SUBJECT: Commitment Letter - Subdivision
Mountain View Electric Association, Inc. (the Association)

Project Name: Cloverleaf Filing #1 - Subdivision

Description: A subdivision is being proposed for 3 individual lots. The lots are based on a Replat of Woodmoor Greens, Tract F and a vacation and replat of Tracts 496-500. Located in Section 23 Township 11 South, Range 67 West.

TRACT F,
WOODMOOR GREENS
PLAT BOOK U-2 PAGE 51

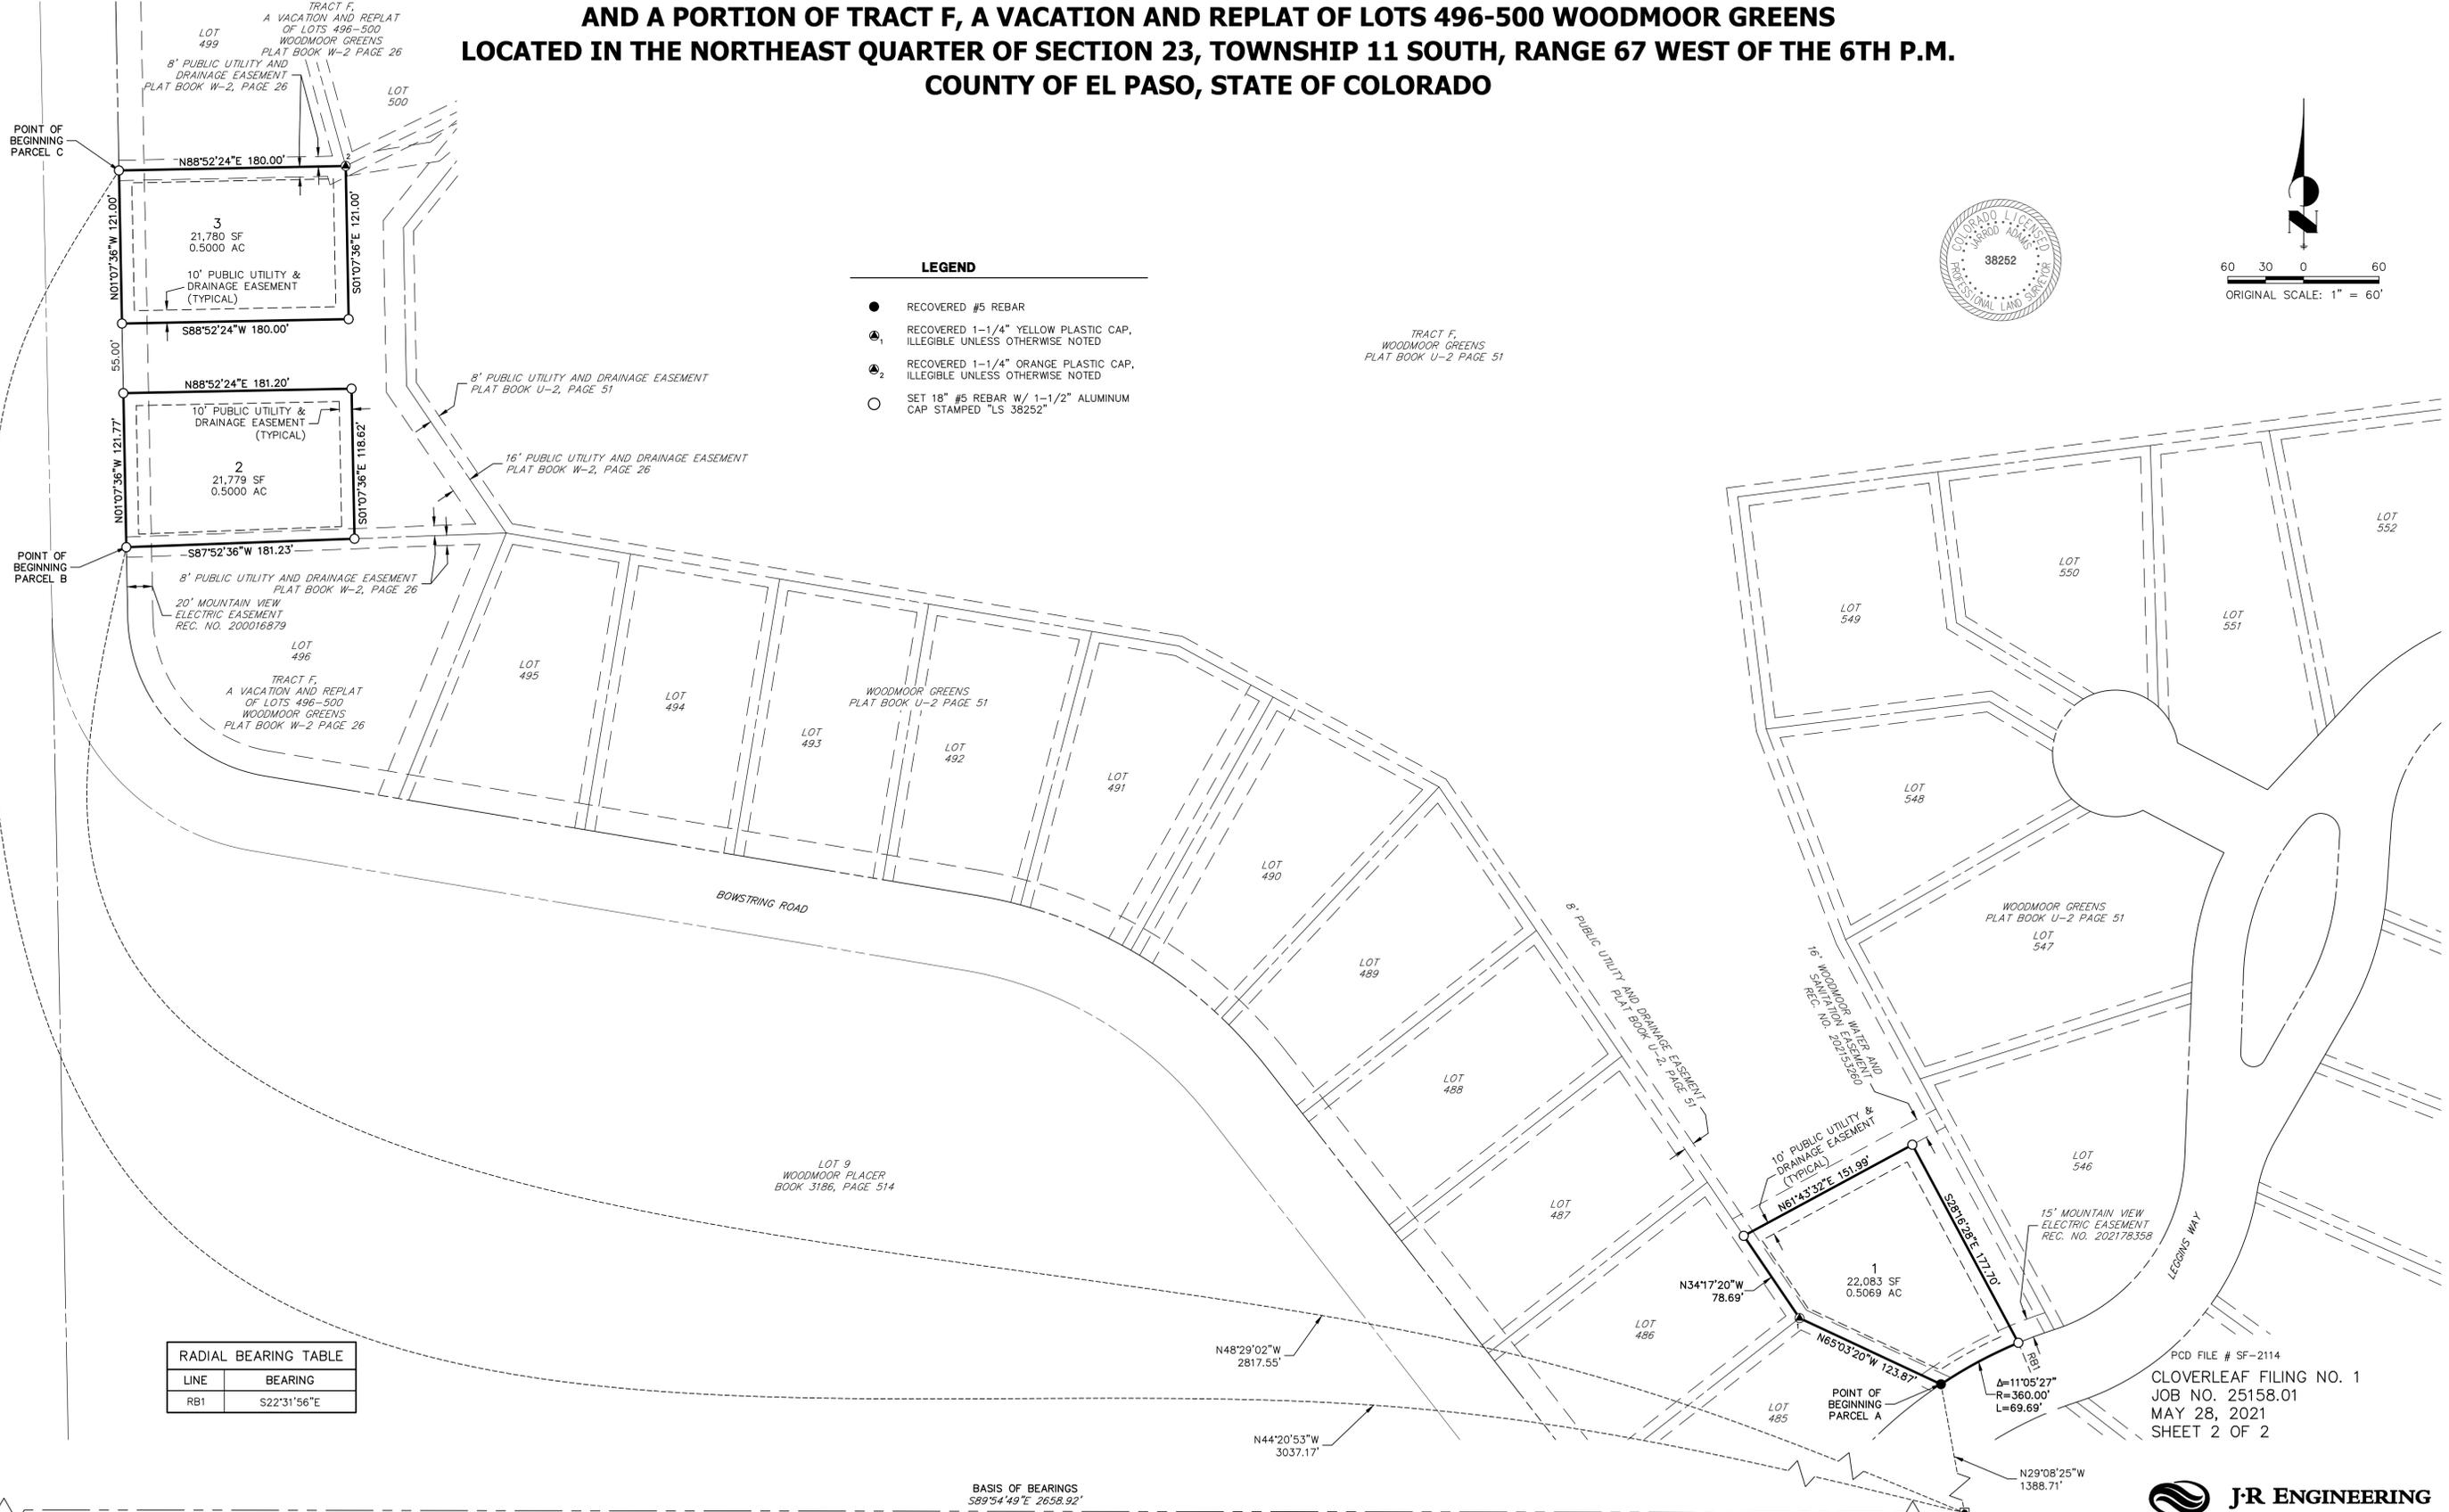
The Association requests a ten (10) foot front lot utility easement, a ten (10) foot side lot utility easement, and a seven (7) foot rear lot utility easement along with a twenty (20) foot exterior utility easement on the plat. The Association also requests the platting of the Association's existing facilities with easement on the plat. Additional easements may be required.
